USM cell antenna project - 44 Bedford St - permit #00940

Christina Stacey <cstacey@portlandmaine.gov>
To: npelletier@trmcom.com

**1 EQUIPMENT PLAN**  
SCALE: N.T.S.

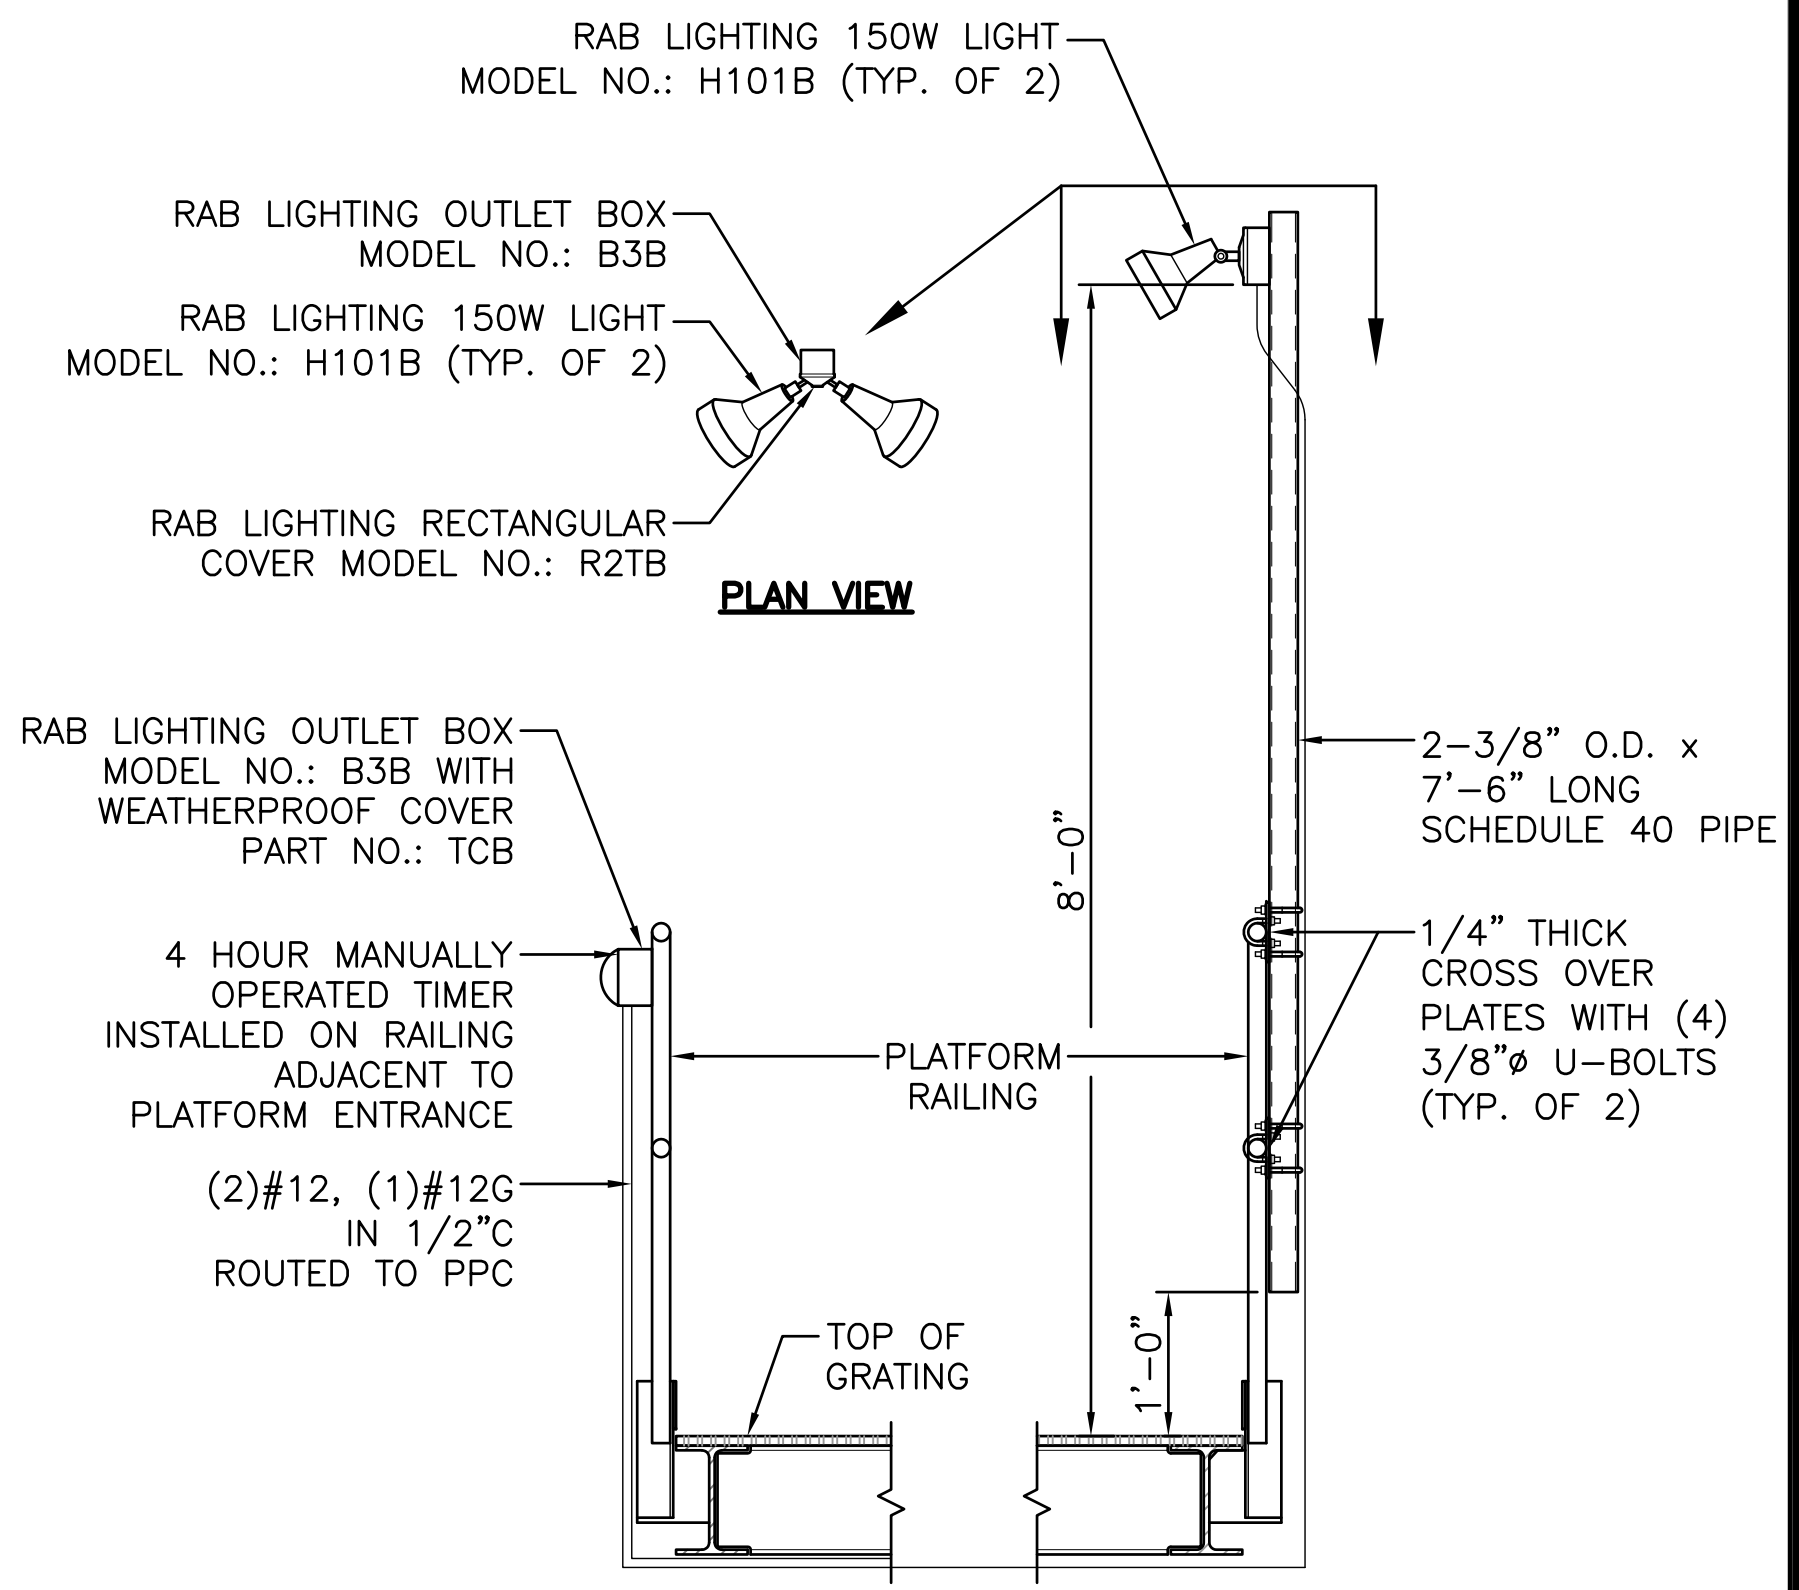
- 1) What will the nature of the "RF transparent" panels be - will they look visually any different than what is there now?
- 2) Is there any visual screening or noise attenuation planned for the generator?

As for the generator, it will be no more visible than the current chiller unit which is present on the roof in the exact same location – that unit will be removed with this project. In fact, being somewhat smaller, it should be less visible if the chiller is visible from the ground as-is. As for sound – a Level II Sound Enclosure will be installed, there should be no increased sound over existing conditions on the roof.

This is helpful. The only condition I would put on it if it was an administrative authorization is that the regular maintenance tests of the generator be conducted between 9 and 5 during the work week.
